**KIRKLEES METROPOLITAN COUNCIL
INVESTMENT & REGENERATION SERVICE**

DELEGATED DECISION TO DETERMINE PLANNING APPLICATIONS

Reference No:	2026/62/91109/W
Site Address:	Ash House, 240, Dunford Road, Holmfirth, HD9 2SJ
Description:	Demolition of existing conservatory and erection of single storey rear extension, works to existing annexe including modification of roof and external elevations, new gate and associated alterations
Recommending Officer:	Joanna Rednall

DECISION – REFUSED

project number  
**2506**  
 drawing name  
**Floor Plans and Elevations A1**  
 - As Proposed  
 drawing number - rev  
**2506.308-01**  
 drawn checked  
 RS SCA  
 paper size  
 scale  
 1:100

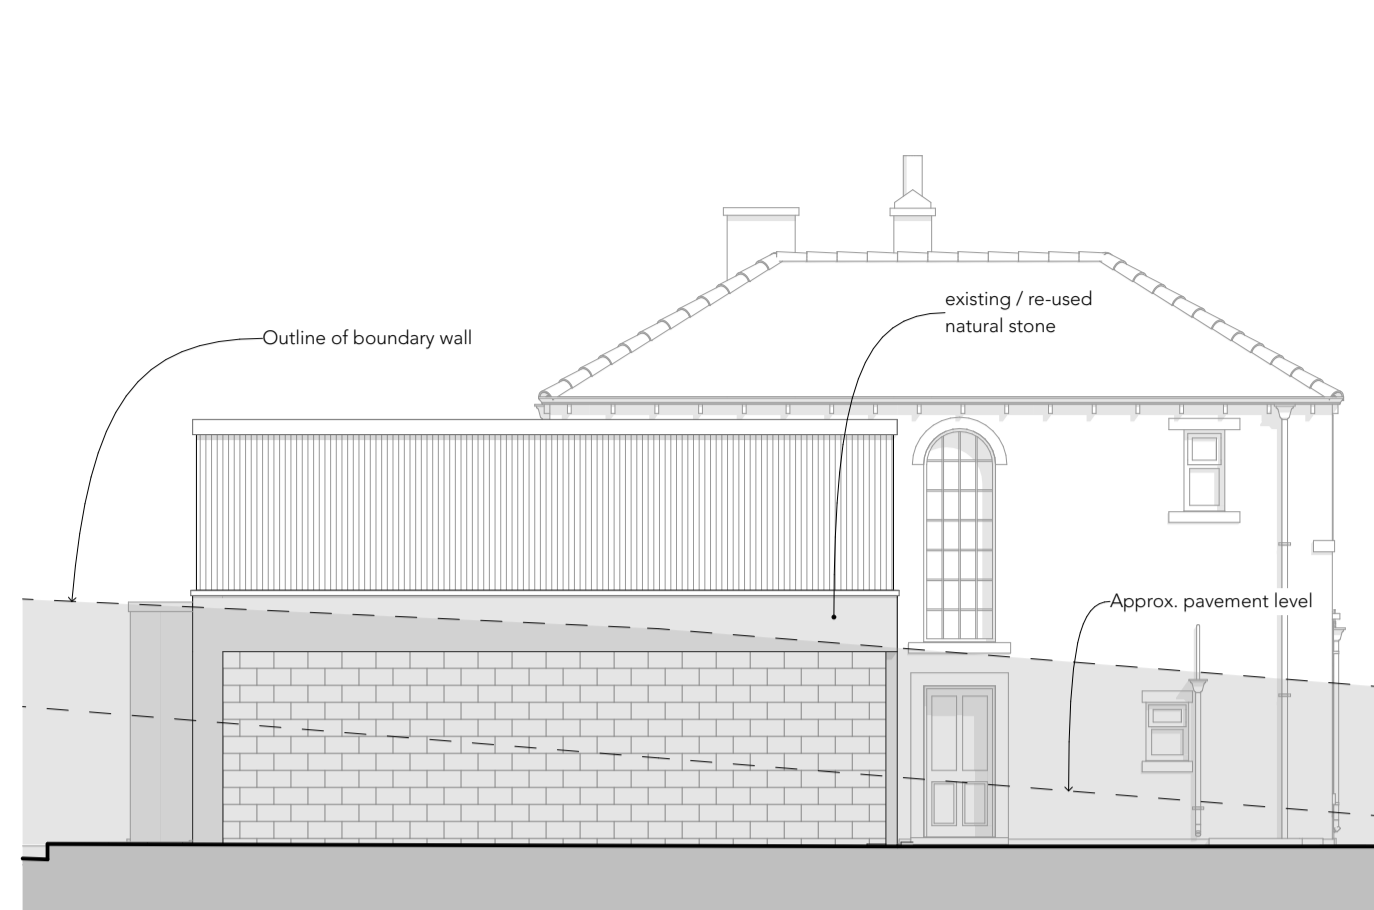
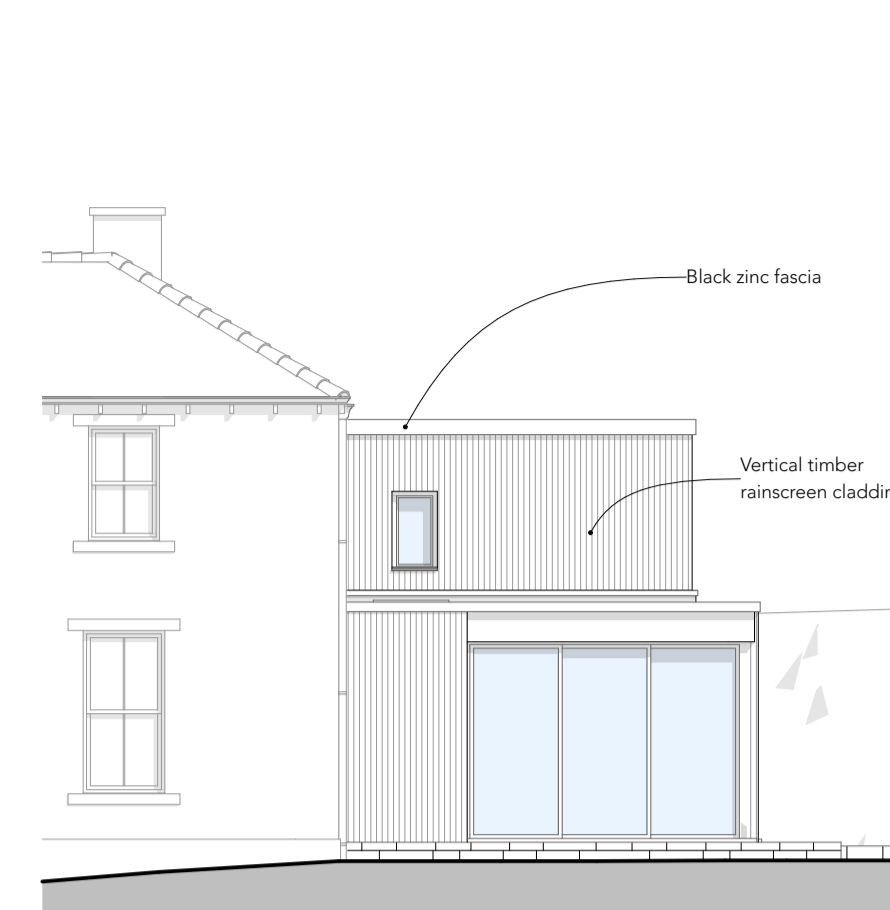
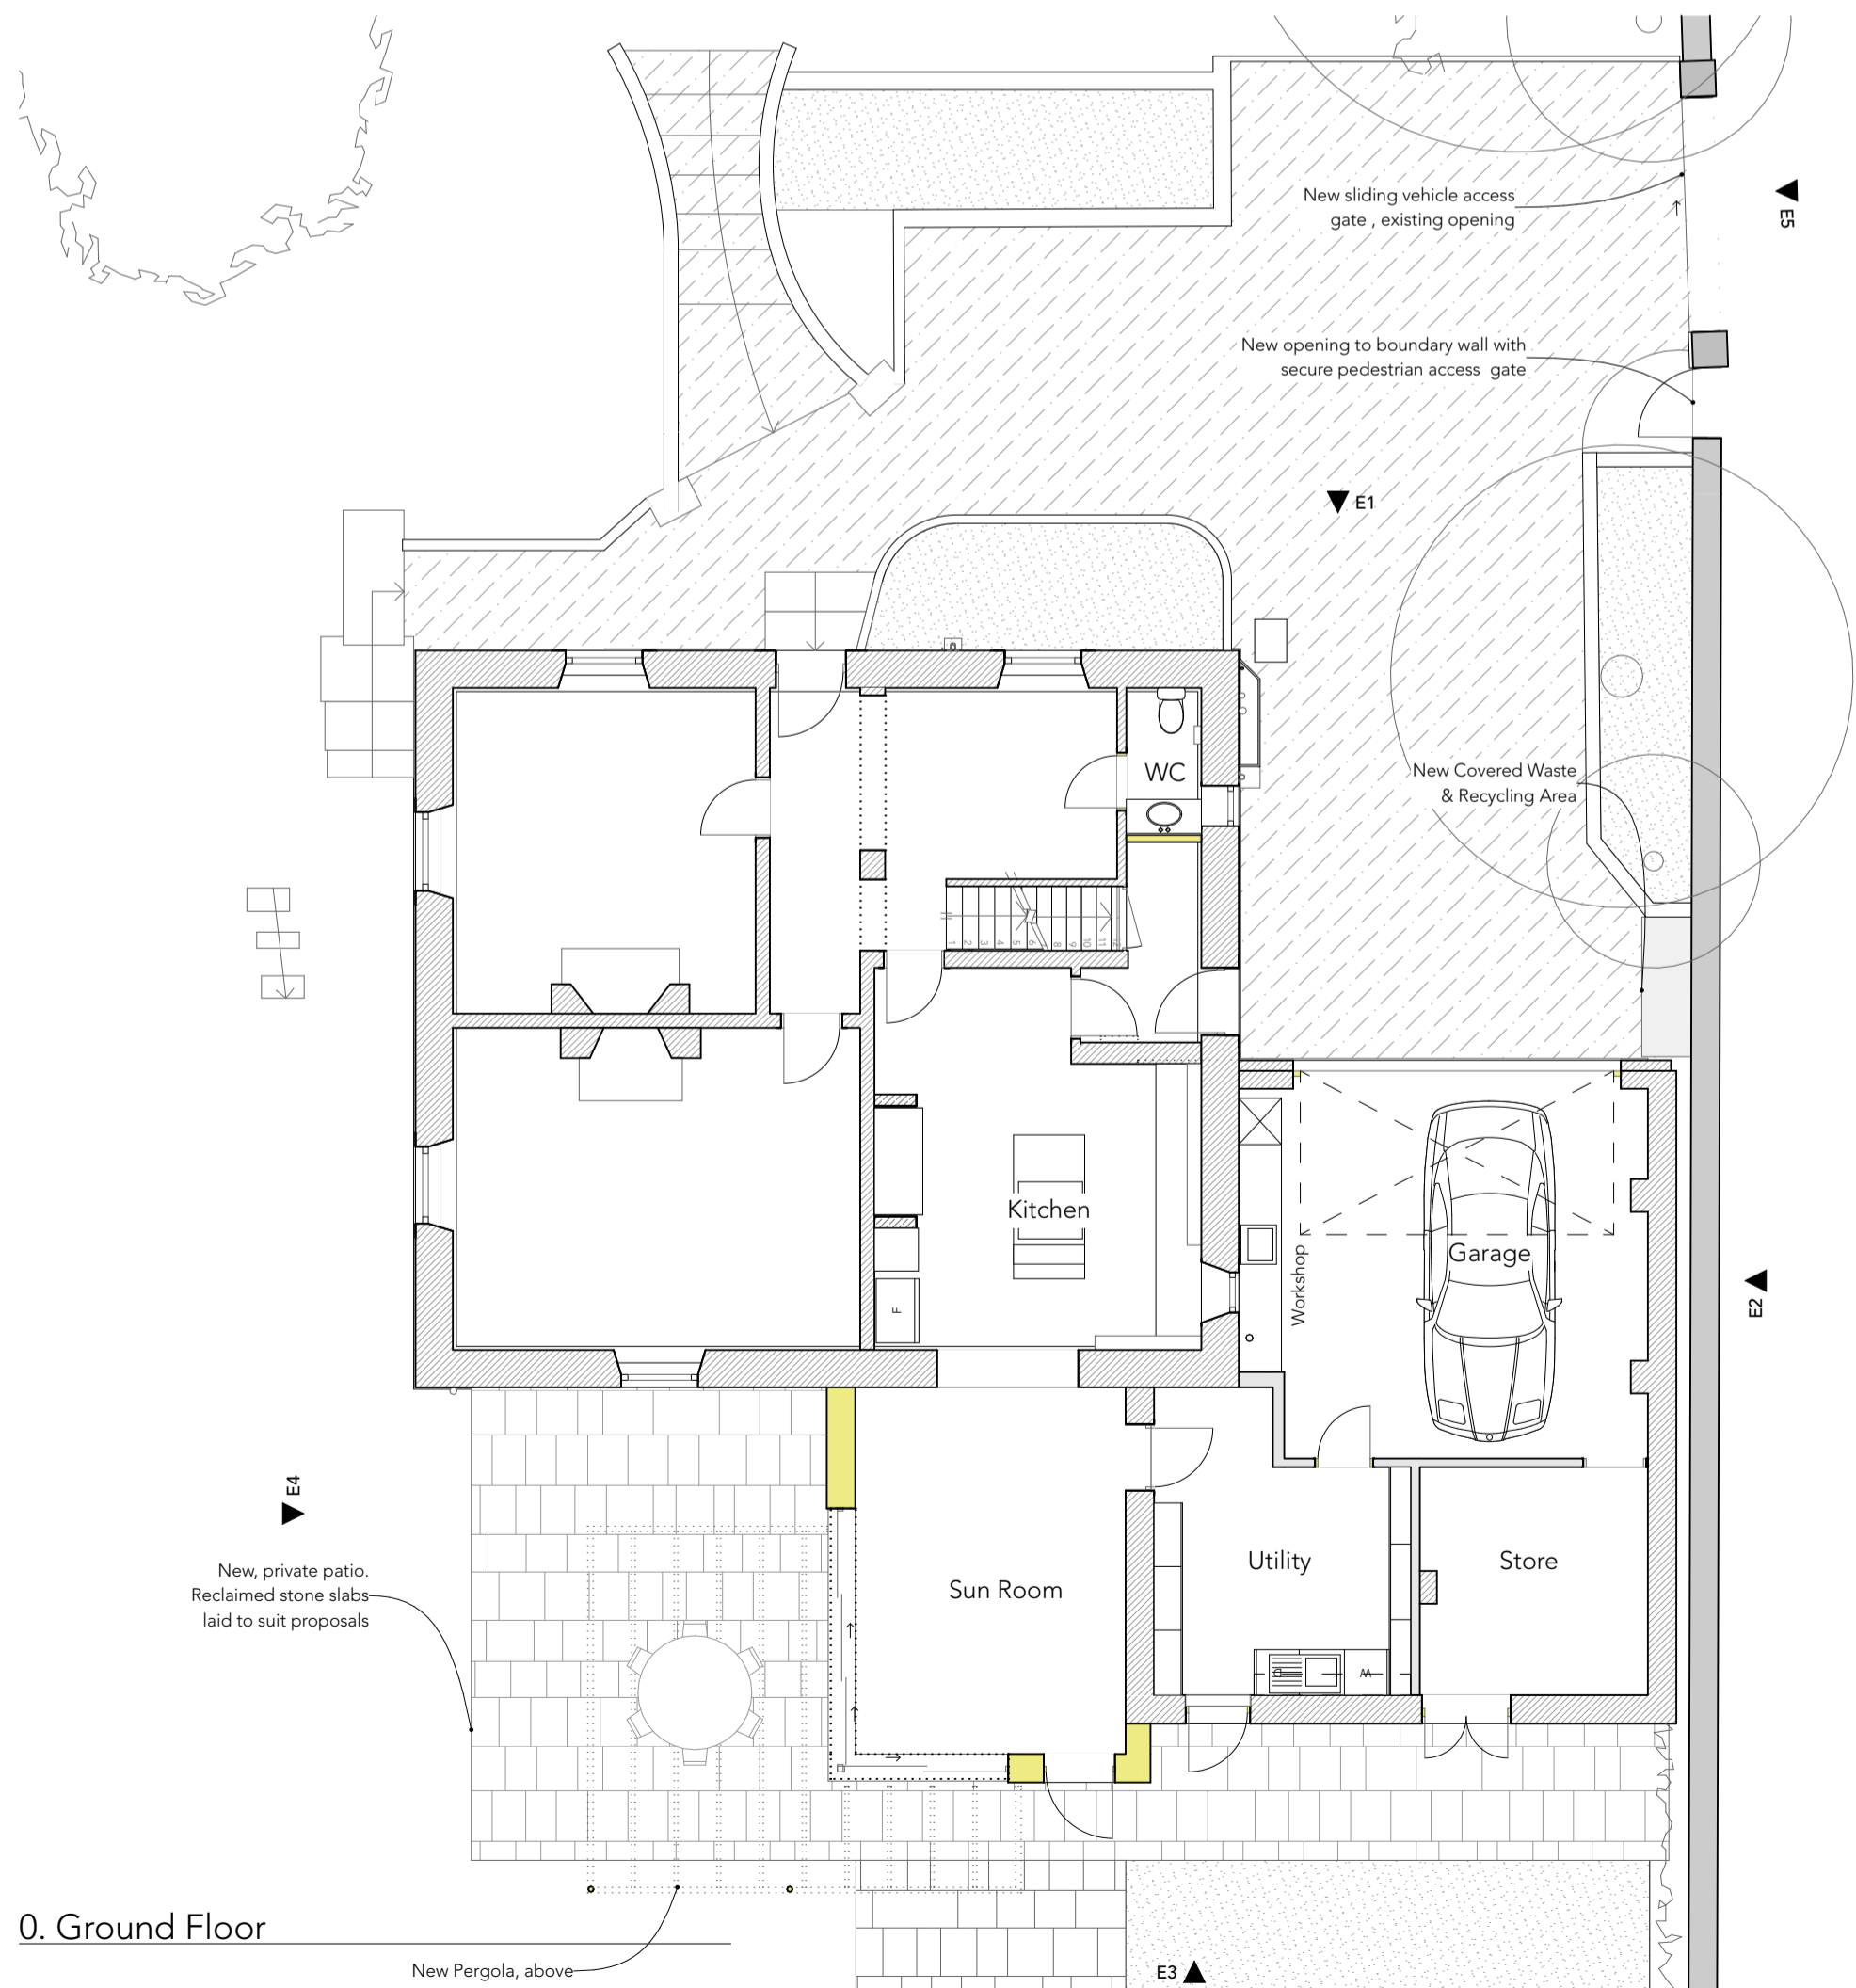
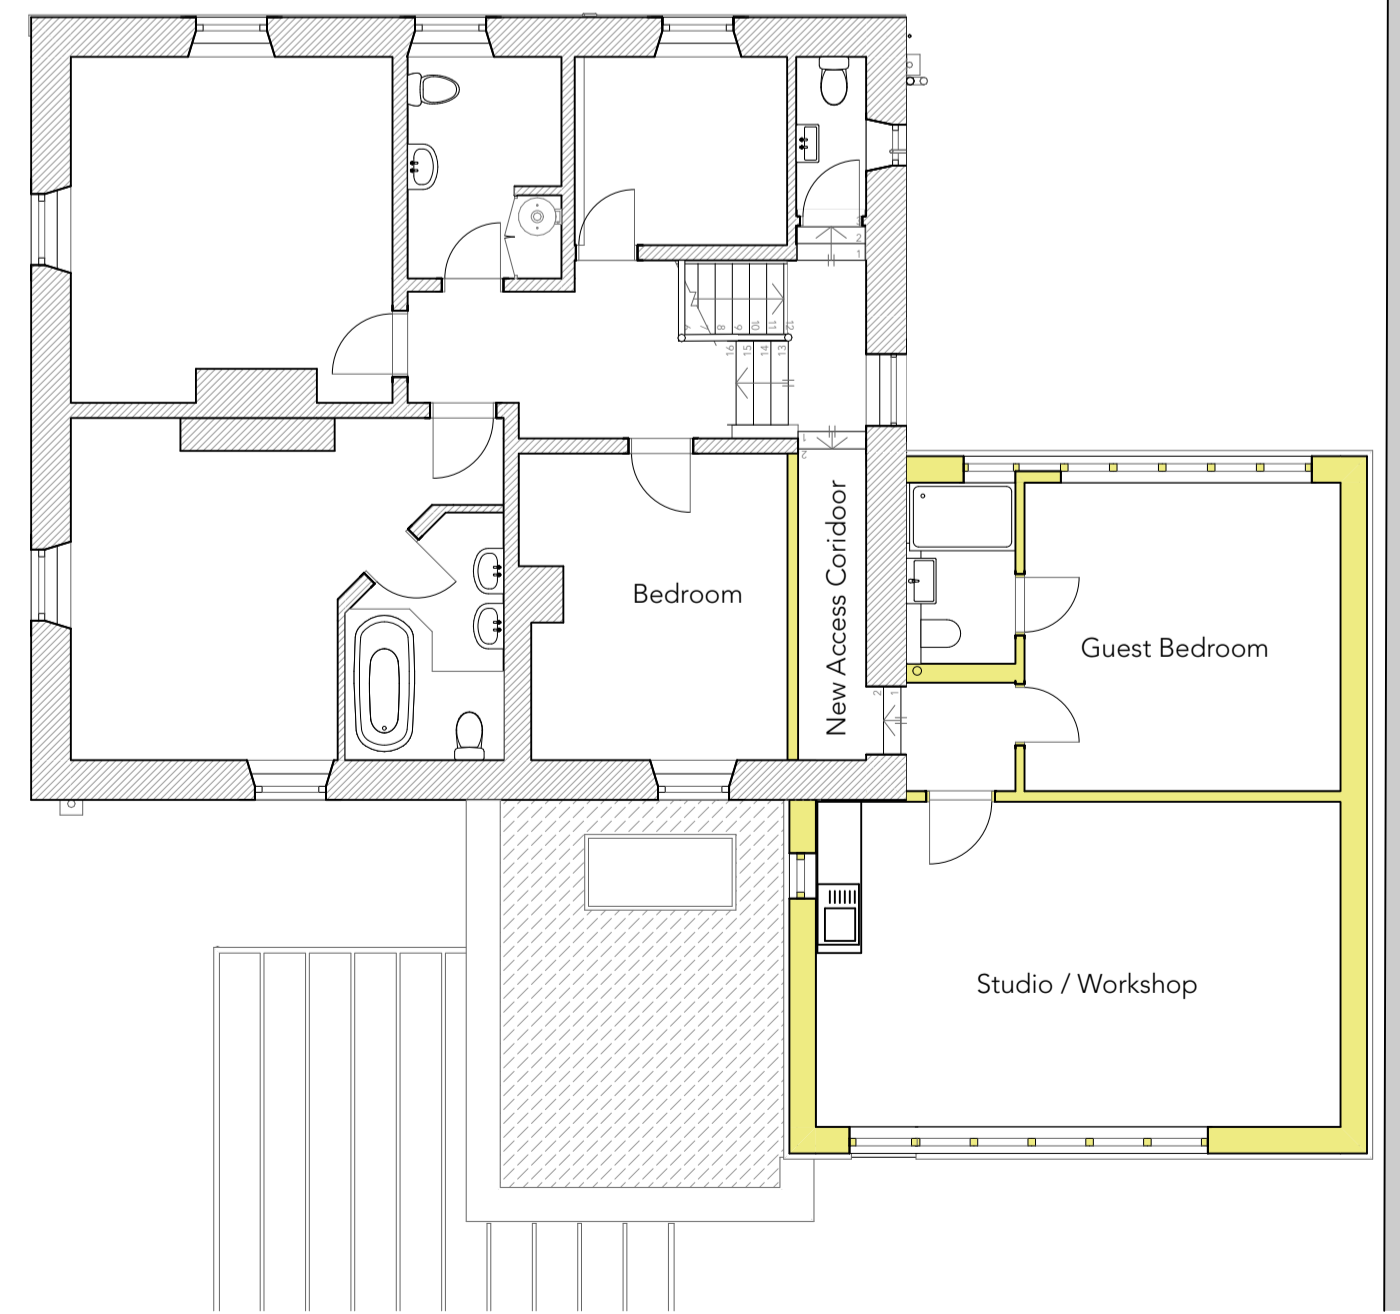
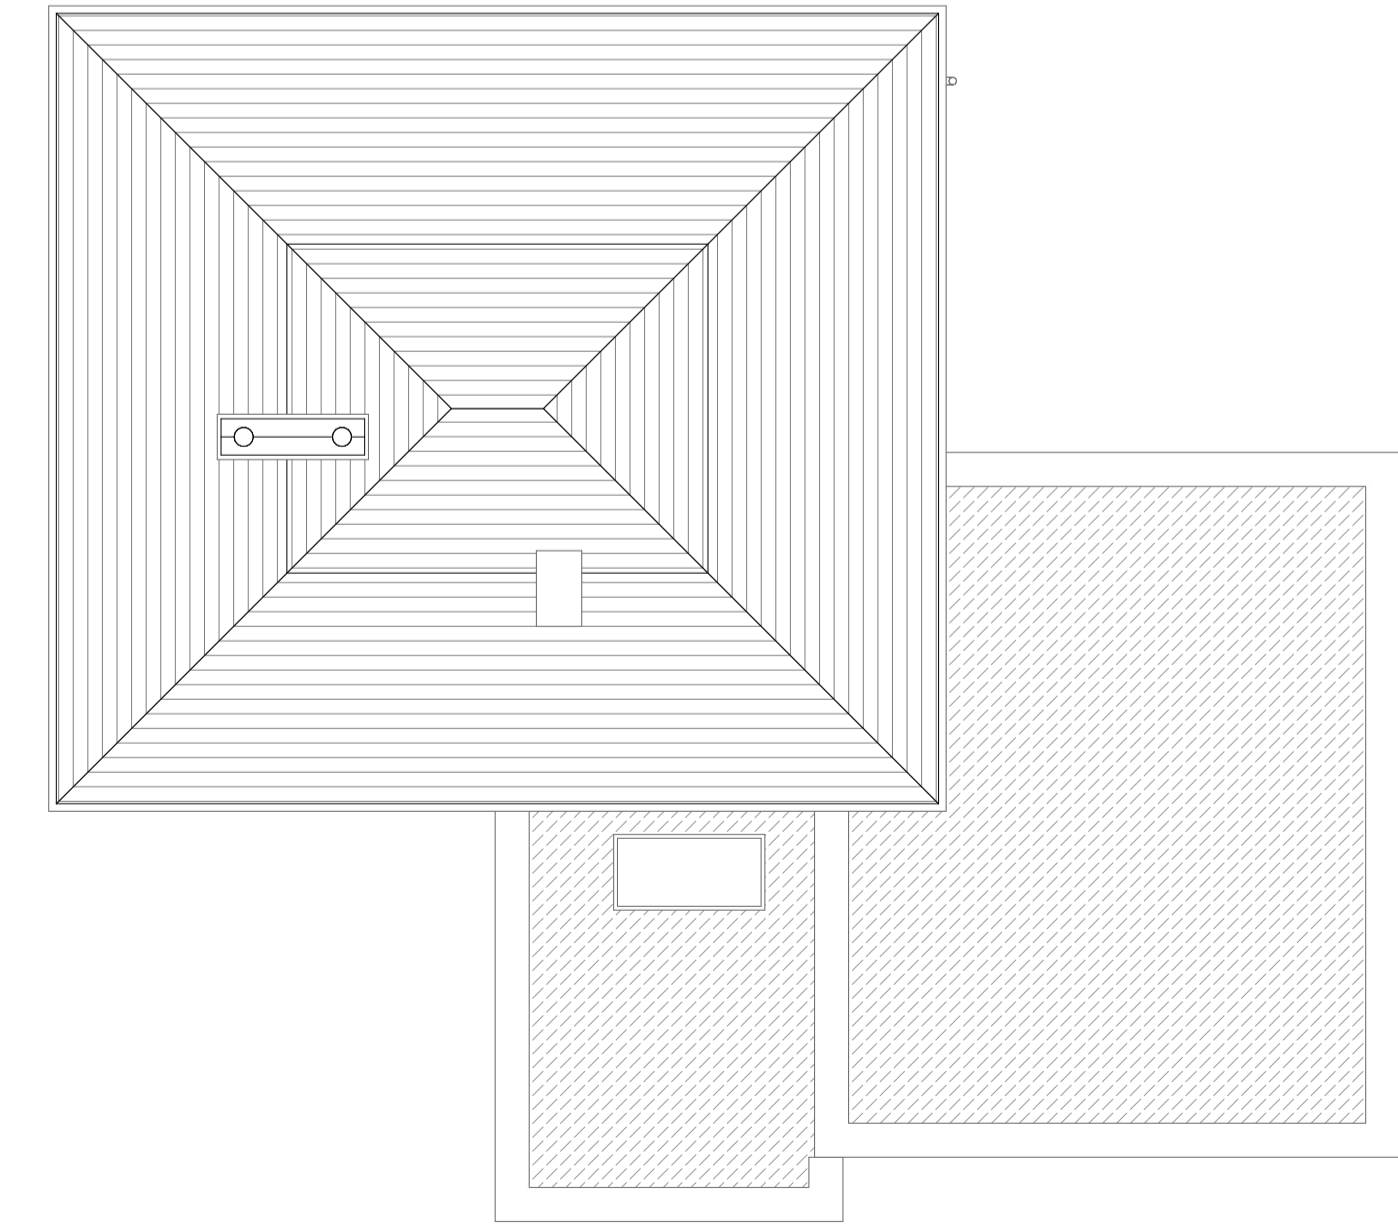
The proposed rear extension would project 5.5m from the existing rear elevation and measure 4.5m in width. It is designed with a flat roof reaching an overall height of approximately 3.5m, finished with black zinc fascia and vertical timber cladding.

The extension incorporates full-height glazed openings to the south and west elevations. A rooflight is also proposed within the flat roof.

The proposed first-floor alterations include replacing the existing hipped roof with a flat roof, increasing the eaves height to 5.4m and achieving an overall height of approximately 5.6m.

The development would introduce revised fenestration, with the north (front) and south (rear) elevations featuring vertically emphasised openings. The

existing twin garage doors would be removed and replaced with a single wider garage door.

In terms of materials, the ground-floor front elevation would remain unchanged. The first floor would be finished in timber cladding to the front, side and rear elevations, while the ground-floor side elevation would be constructed in natural stone.

Internally, the development would serve a bedroom and studio / workshop. The submitted plans show that the vehicle gate would retain the same overall dimensions as the existing gate but would operate as a sliding gate rather than opening inward. It would remain in its current position, with a new pedestrian gate proposed immediately to the side. Both gates are proposed to be finished in a black powder-coated material.

In this case, the proposed extensions would introduce a distinctly modern form, characterised by flat roofs, vertical timber cladding, and full-height glazing. These elements contrast sharply with the host dwelling, which is a traditional stone-built property with a hipped roof and a more modest, vernacular character. The resulting development would create a large, flat-roofed mass extending along the side elevation and projecting beyond the rear at two storeys before stepping down to a single storey. This would produce a form that does not respect the scale, proportions, or architectural language of the original dwelling, conflicting with the aims of LP57(a) of the Kirklees Local Plan.

With regard to materials, the extensive use of timber cladding on the first-floor extension and rear extension would appear visually incongruous against the traditional natural stone of the host building. Policy LP57(d) requires that materials have regard to relevant design policies and do not materially detract from the Green Belt setting. In this instance, the cladding would introduce a contrasting and visually assertive finish that would erode the historic and architectural integrity of the original dwelling.

The proposed vertically emphasised windows would further accentuate this contrast. Their aluminium-faced, dark grey finish and full-height proportions would sit at odds alongside the traditional white uPVC / painted timber sliding-sash style windows of the host. These changes would further highlight the contrast between the extension and the original dwelling. The development would occupy a prominent position, running parallel to Dunford

As set out earlier in Section 1 of this report, the proposed extensions would result in a disproportionate increase over the size of the original dwelling and would introduce a distinctly modern design language, including flat roofs, vertical timber cladding, and full-height glazing. These contemporary elements contrast starkly with the traditional natural stone construction and hipped roof form of the host property, which currently contributes positively to the character and appearance of the Conservation Area's setting. The increased massing, combined with the use of contrasting materials and modern detailing, would erode the visual coherence of the area and diminish the

1. The proposed development, by reason of its design, siting and scale, would result in the construction of an incongruous and unsympathetic

development which would fail to harmonise with the host dwelling and would be detrimental to the character and appearance of the host property. The proposal therefore fails to accord with Policy LP24 of the Kirklees Local Plan, Key Design Principles 1 and 2 of the Kirklees House Extensions and Alterations Supplementary Planning Document, Policy 2 of the Holme Valley Neighbourhood Development Plan and policies within Chapter 12 of the National Planning Policy Framework.

2. The proposed development, by virtue of its design, siting and scale constitutes a disproportionate addition and would therefore be inappropriate development within the Green Belt. No very special circumstances have been demonstrated or are considered to exist more generally that outweigh the identified harm. The proposal therefore fails to accord with policies within Chapter 13 of the National Planning Policy Framework and policy LP57 of the Kirklees Local Plan.

3. The proposed development, by virtue of its design, siting and scale, has a harmful impact upon the historic character and setting of Underbank Conservation Area. There are no public benefits identified or considered to exist more generally which justify the identified harm to the setting of the Conservation Area and the development is therefore contrary to Policies LP24 and LP35 of the Kirklees Local Plan, Principles 1 & 2 of the Council's adopted House Extensions and Alterations Supplementary Planning Document, policies within Chapters 12 and 16 of the National Planning Policy Framework and Section 72 of the Town & Country Planning (Listed Buildings & Conservation Areas) Act 1990.
